KITTITAS COUNTY DEPARTMENT OF PUBLIC WORKS

MEMORANDUM

SUBJECT: B Proctor Short Plat SP-08-00058

B. PROCTOR SHORT PLAT
A PORTION OF THE SE 1/4 OF SEC. 12, T2N, 17N, R9E, 19E, W.M.
KITTITAS COUNTY, WASHINGTON

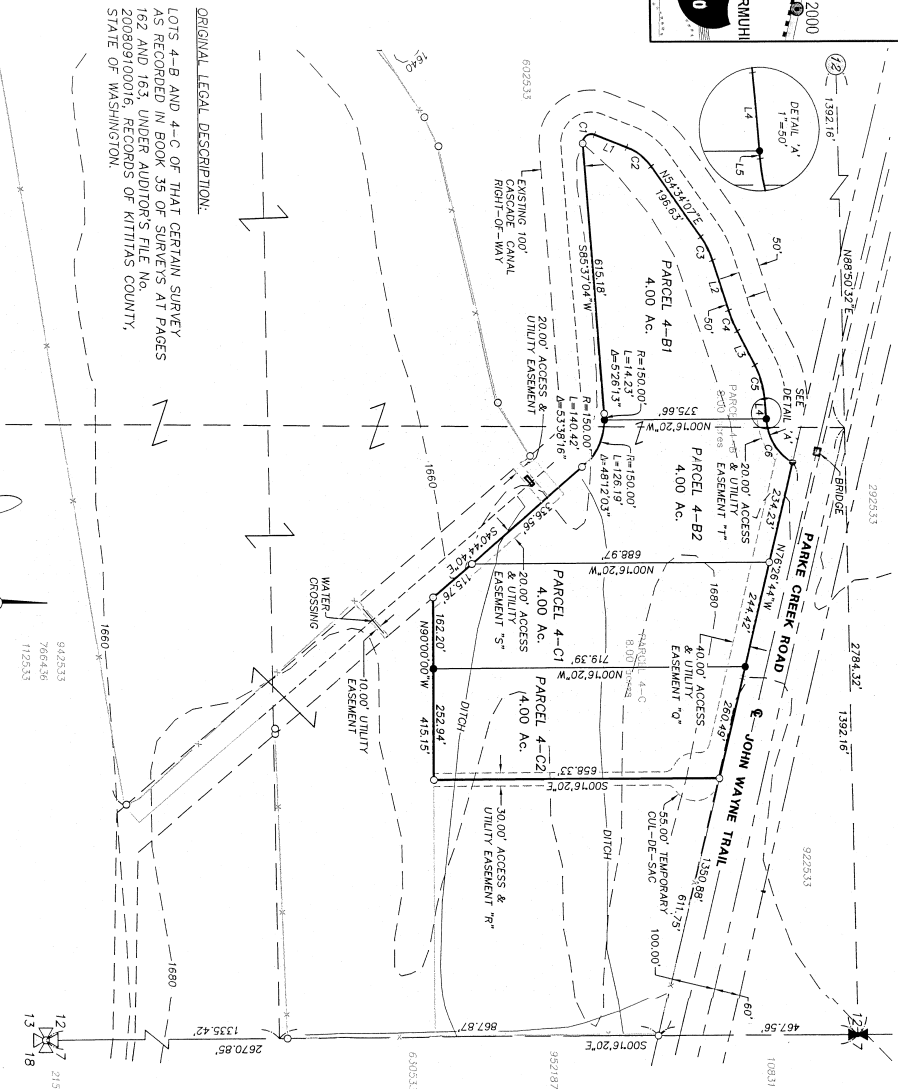
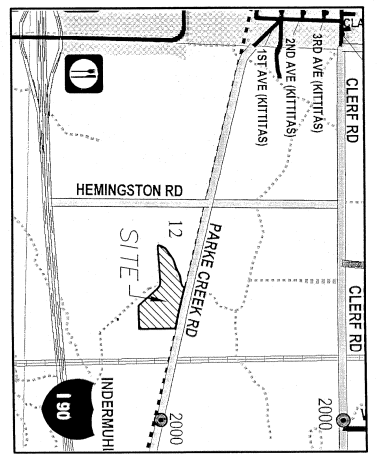
4. Private Road Improvements: Access from Parke Creek Road to the cul-de-sac shall be constructed to meet or exceed the requirements of a High-Density Private Road that serves 3-14 tax parcels. See Kittitas County Road Standards, 9/6/05 edition.

- a. Access easements shall be a minimum of 40' wide. The roadway shall have a minimum width of 20', with 1' shoulders, for a total width of 22'.
 - b. Minimum centerline radius will be 60'.

- c. Surface requirement is for a minimum gravel surface depth of 6".
 - d. Maximum grade 8% flat, 12% rolling or mountainous.
 - e. Stopping site distance, reference AASHTO.

5. Cul-de-Sac: A cul-de-sac turn-around having an outside right-of-way or easement diameter of at least 110 feet shall be constructed at the closed end of all dead-end roads serving 3 or more lots. The driving surface shall be at least 96 feet in diameter. Cul-de-sacs must also conform to the requirements specified by the 2006 International Fire Code. Contact the Fire Marshal regarding any additional cul-de-sac requirements.
